25th April 2022

**ref Y/36/22/HH – Erection of detached workshop, gym/hobby and greenhouse at
Berri Court, Main Road, Yapton BN18 0ED**

Title
PROPOSED PLANS, ELEVATIONS
& SECTION

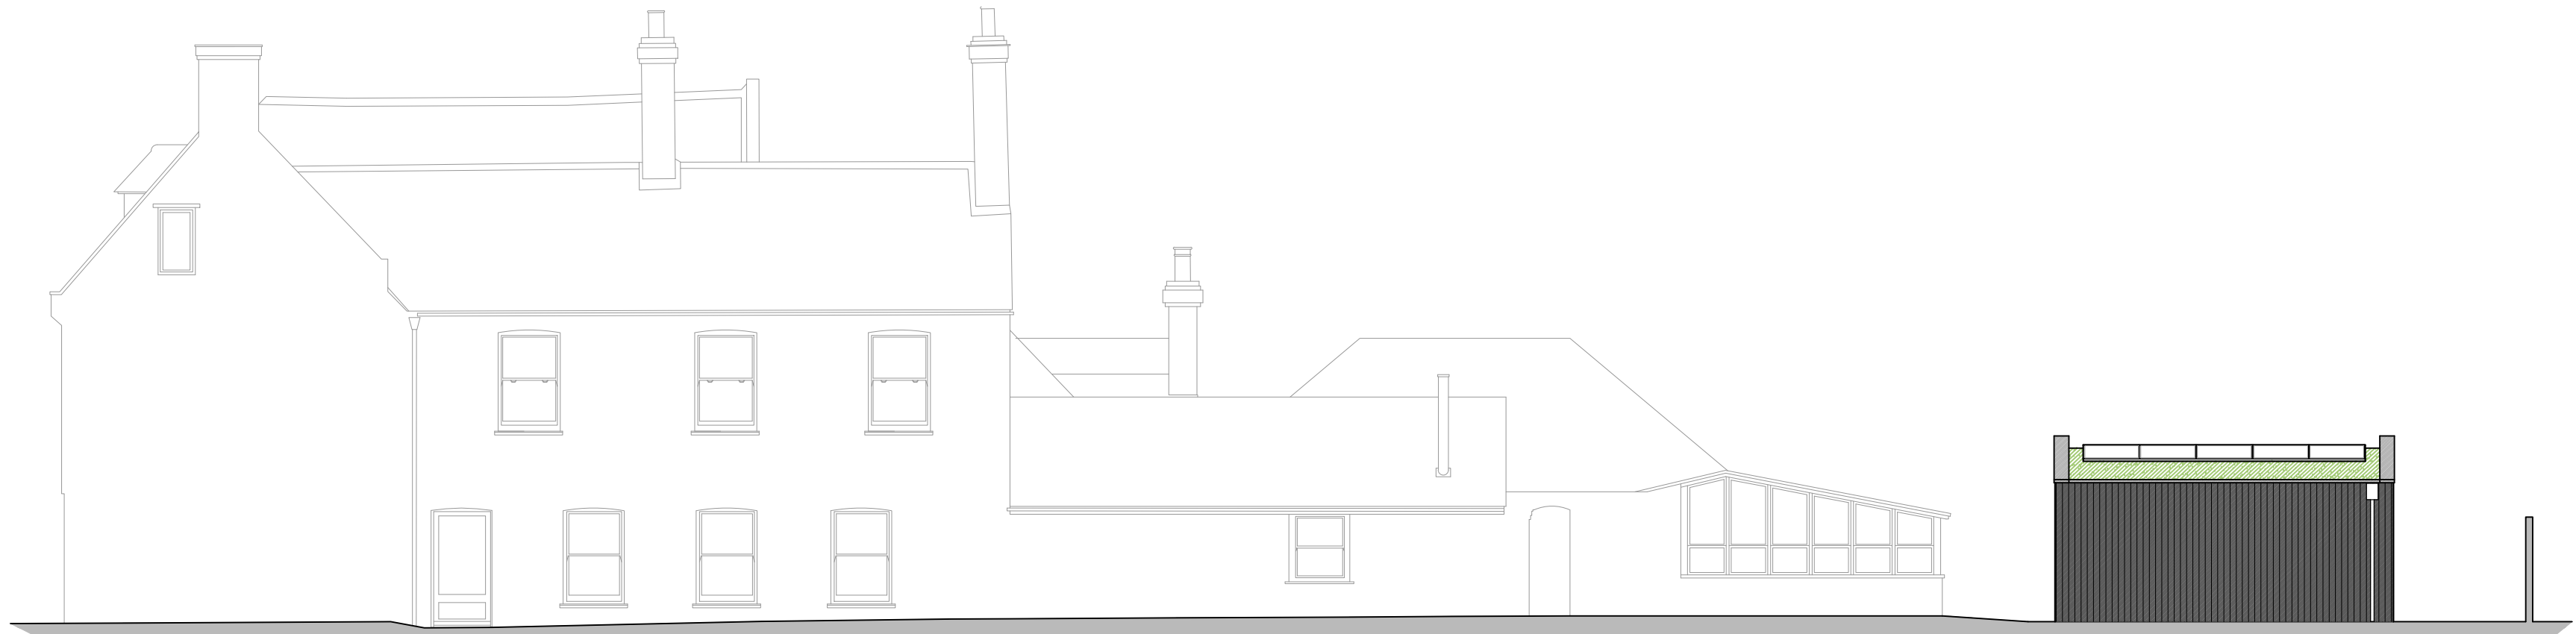
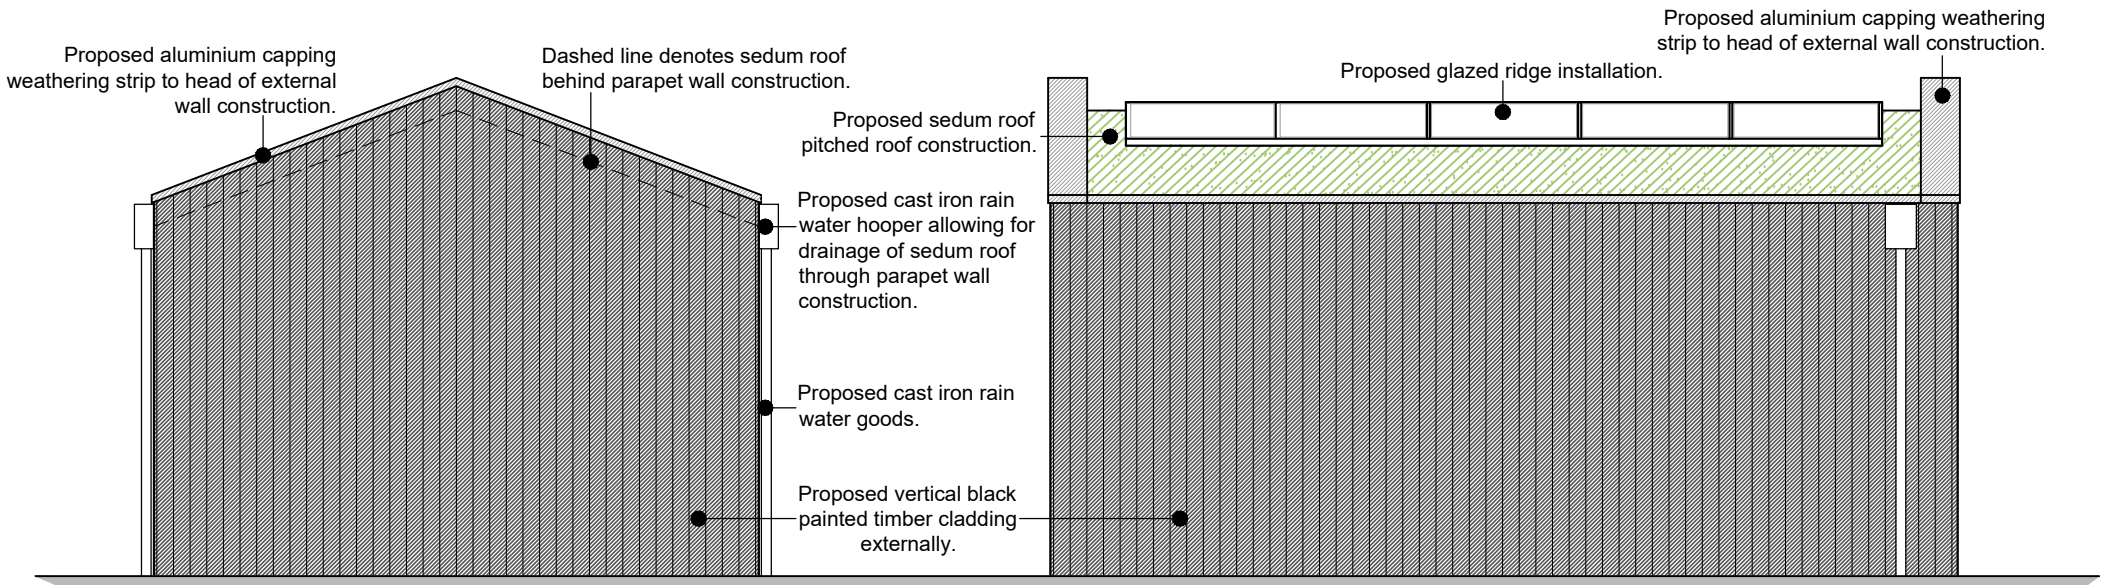
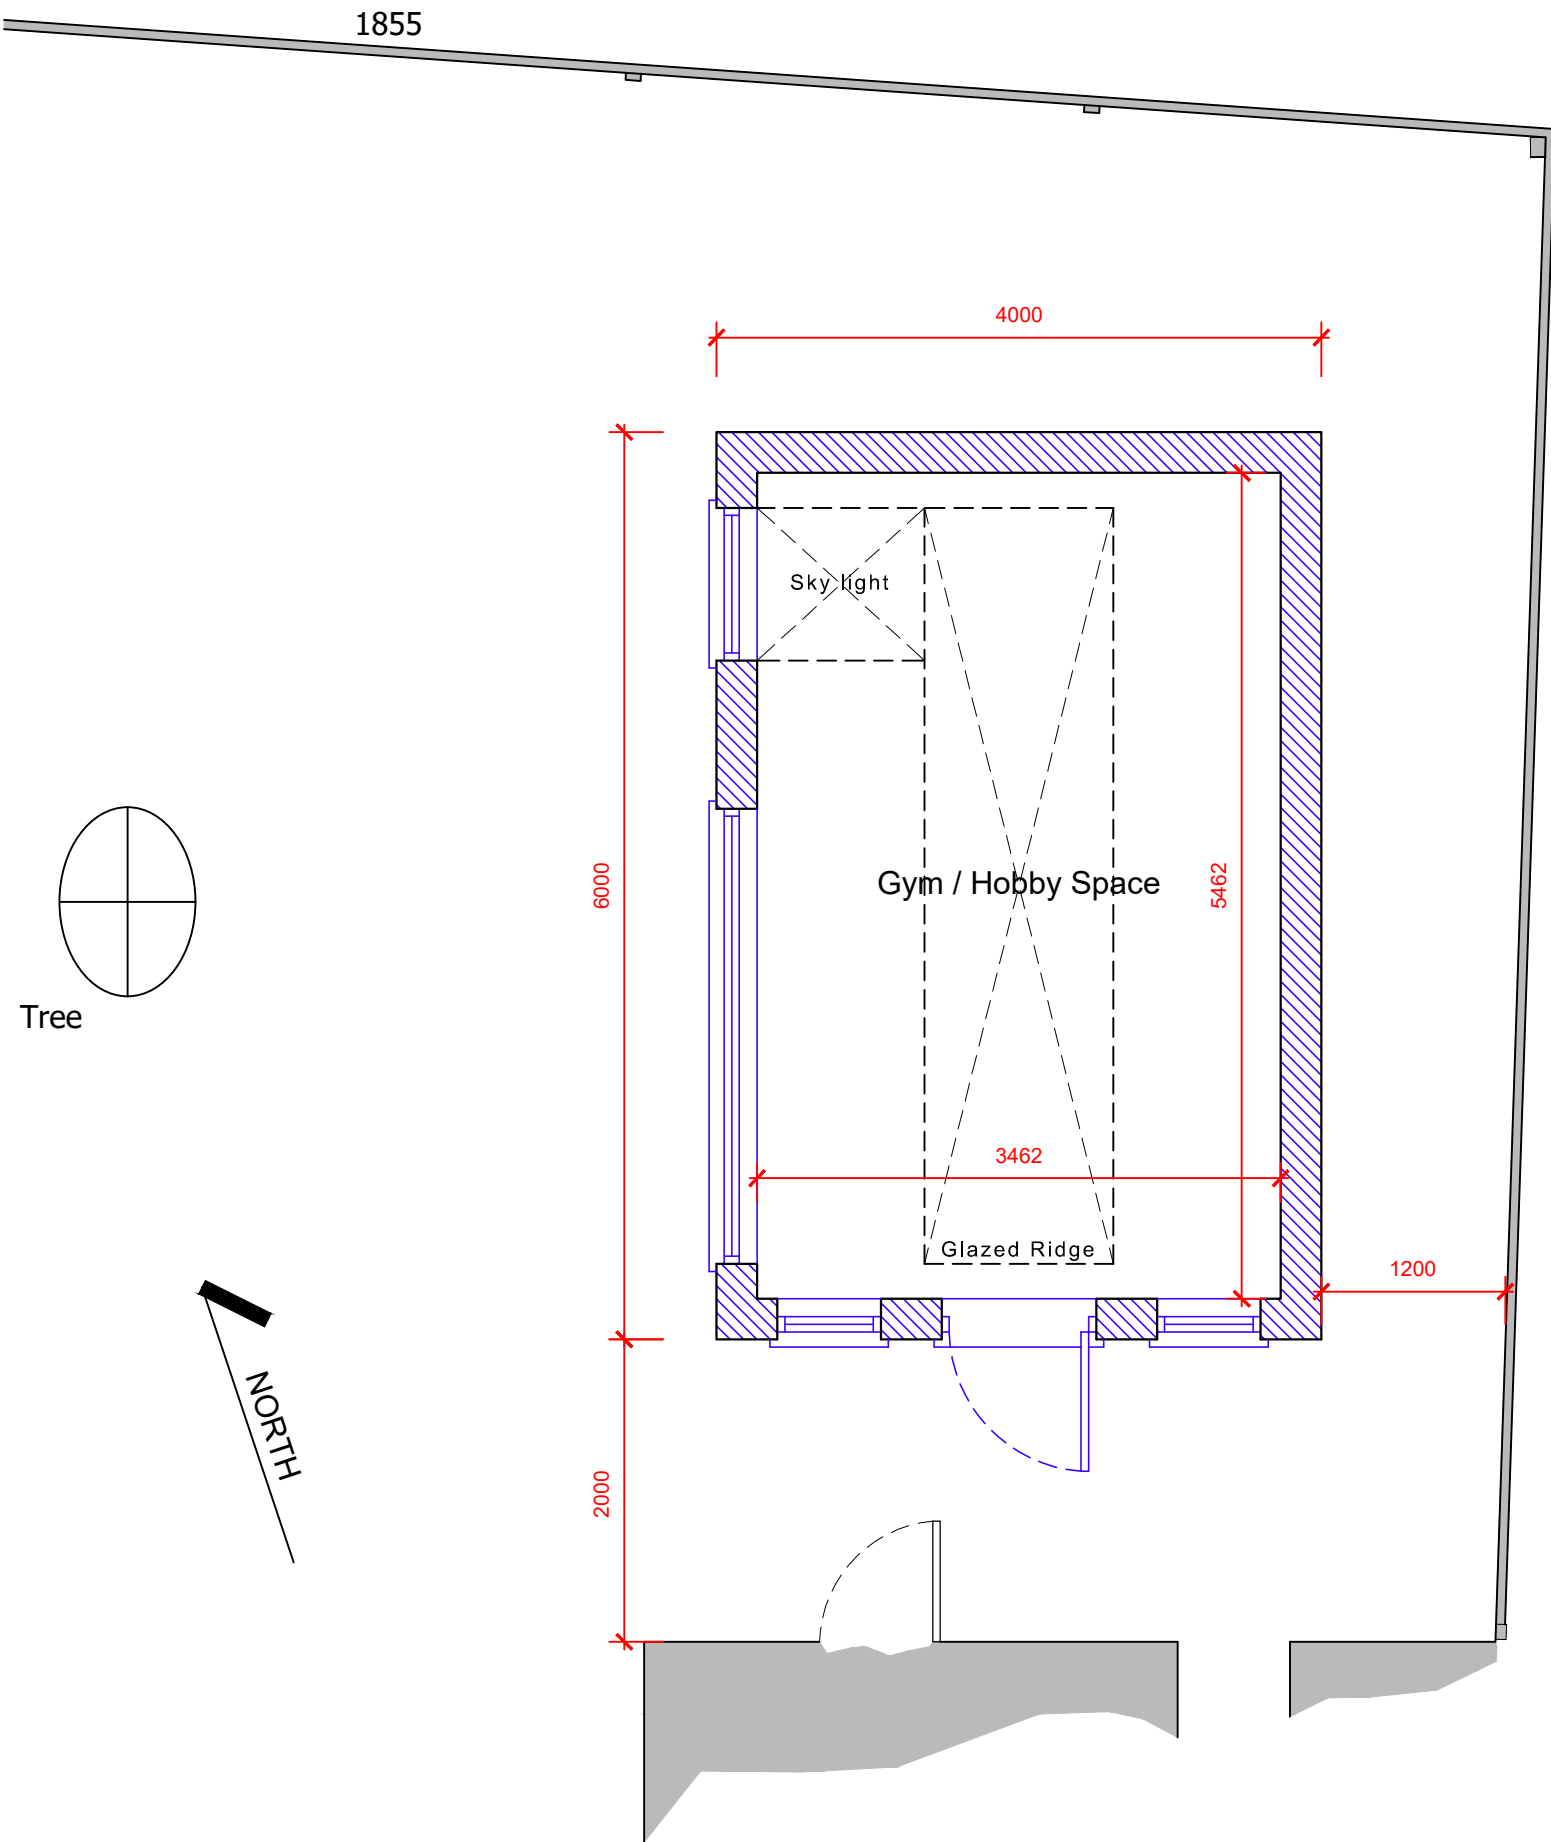
3. Berri Court is a distinguished-looking listed building. It falls within the Conservation area (Main Road/Church Lane, Yapton) designated in 1994. Whilst the proposed design of the greenhouse could be regarded as sympathetic, the workshop and gym/hobby room could not be described as being neutral to, let alone enhancing, the character and appearance of the property and its grounds.
4. The heights of the structures proposed exceed the height of the existing boundary wall. In particular, as planned, the workshop would be directly in the line of sight from my conservatory and patio area. Quite apart from aesthetic considerations, it would reduce the amount of natural light to my garden.

Could the option to re-site the workshop (against the boundary with the surgery car park for instance) be explored? If not, would it be possible to reduce the height of the proposed workshop or relocate further away from the flint wall, such that at least no black painted timber cladding was visible from my property?

Title
SITE PLANS

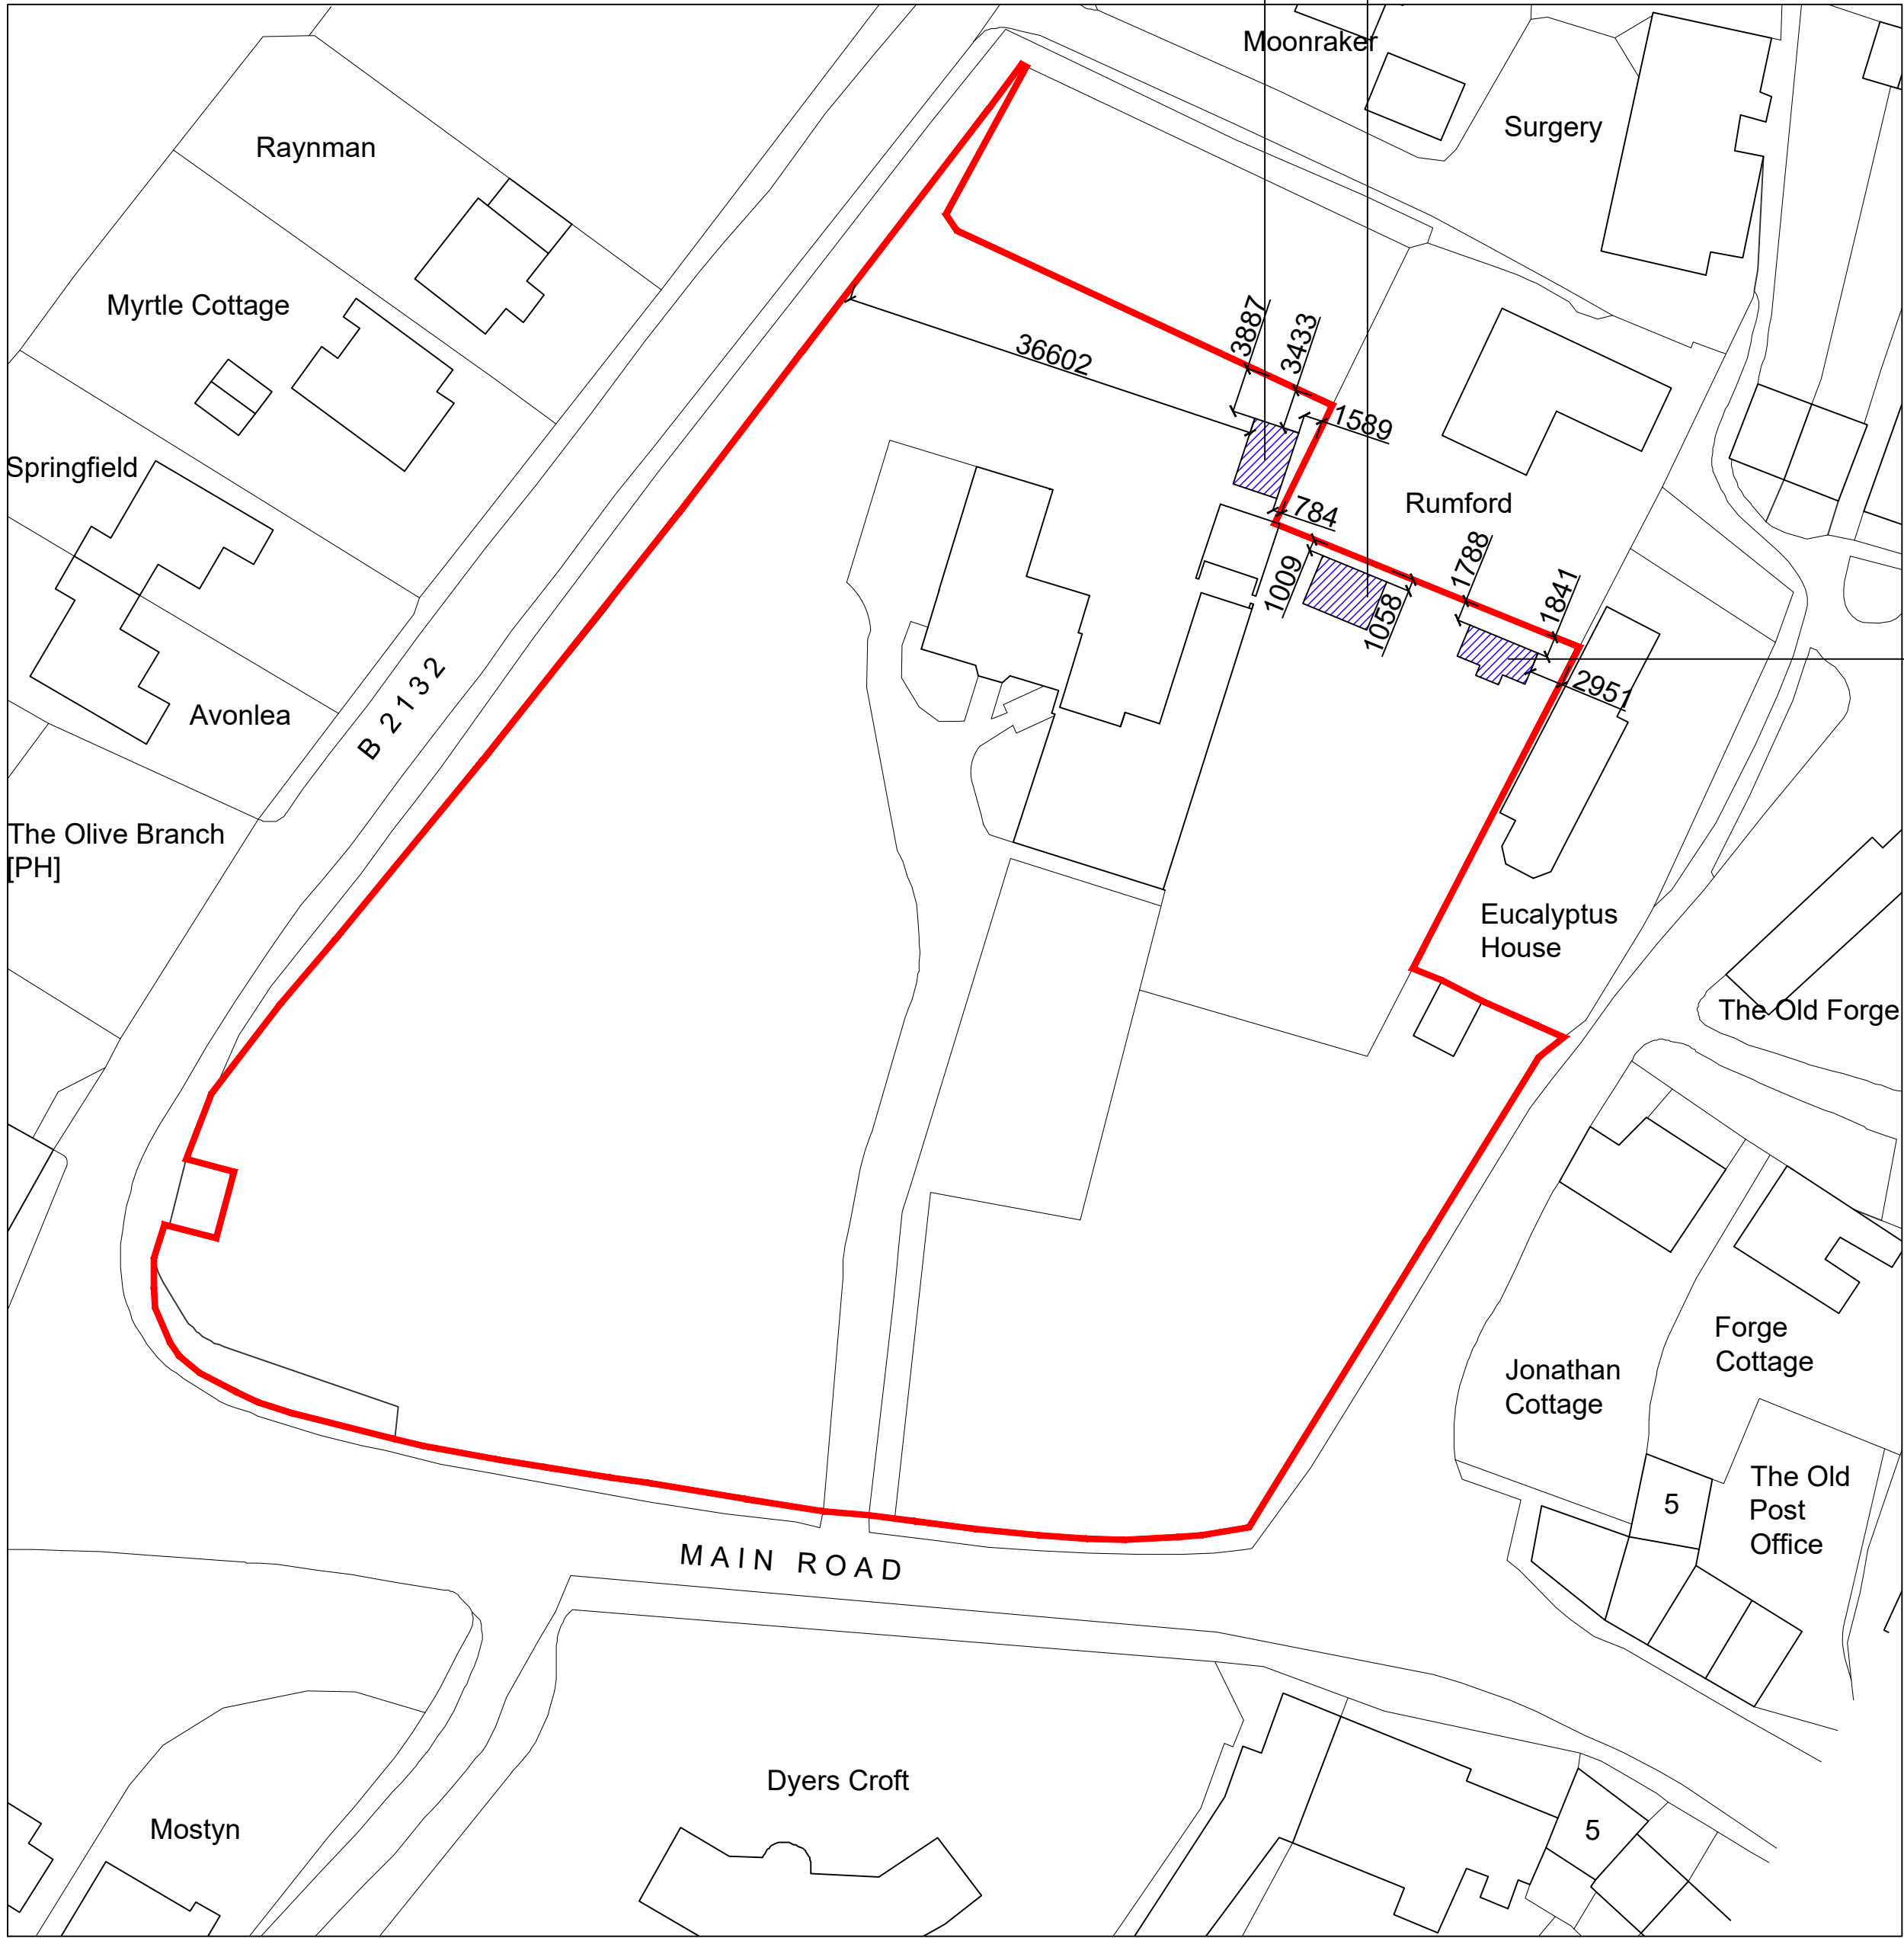
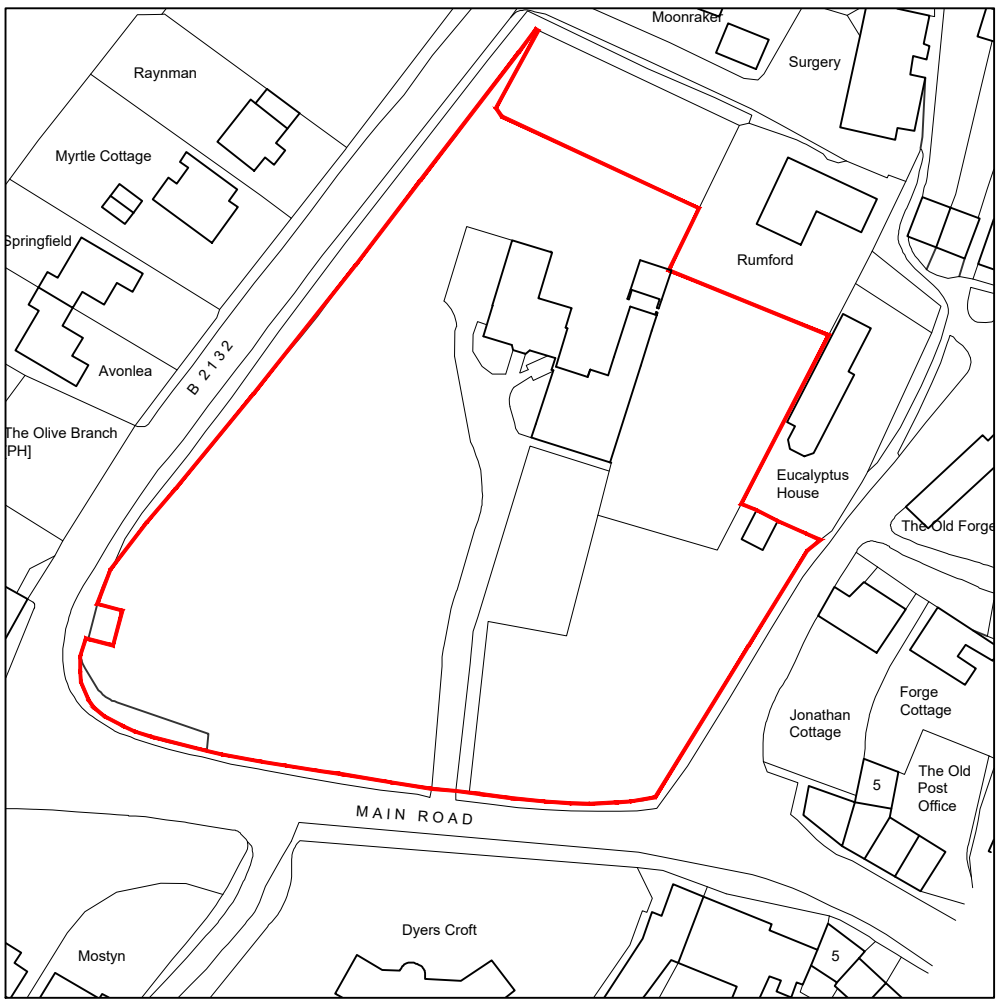
This is misleading. The overall site plan submitted (Drawing No.1 Rev D) is out of date. In relation to Rumford House, it shows neither the conservatory erected in 2002, nor the one-story extension to the house built in 2013. As a consequence, the plan gives a false impression of the amenity space available at Rumford, particularly to the south and west. The structures proposed under this application are located close to the southern and western boundaries of my property. The proposed gym/hobby room and workshop buildings are both higher than the existing boundary wall. Their locations and height will result in over-dominant structures that will hem in and adversely affect the amenity value of the main private amenity space of Rumford.

2. The application is short of a Tree Report and no trees are shown on the site plan. There is one large tree in close proximity to the proposed Gym/hobby room but this is not shown on the plan. Prior to the submission of this application, there has been some considerable clearing of trees and shrubbery.
